*Ribble Valley Borough Council.*

*Planning application No; 3/2021/0667*

SIGN 2

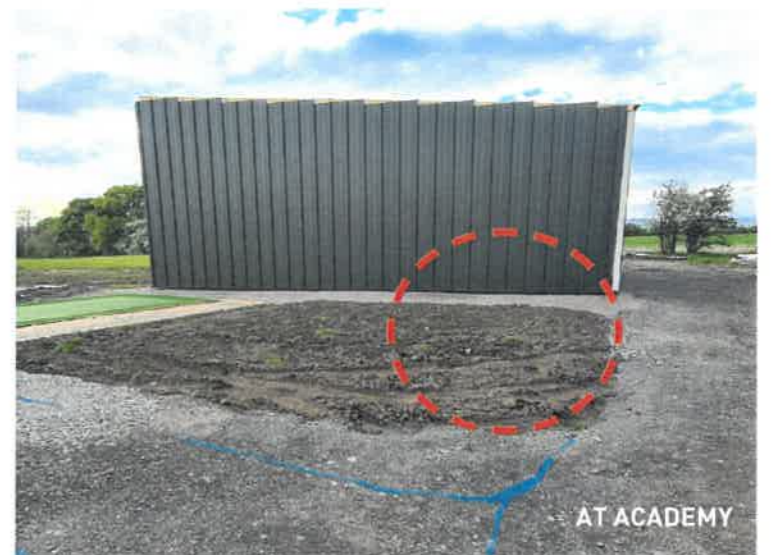
*I wish to make objection to the post mounted signs proposed by this application. It is my contention that these signs are visual clutter, and will detract from the efforts, made by the Golf Club, to landscape the site.*

*This objection applies particularly to signs 2 & 3 (which change places on the location plan and the site plan). Persons wishing to use the facilities of the golf academy are hardly likely to need reminding of where they are at approximately 30-meter intervals.*
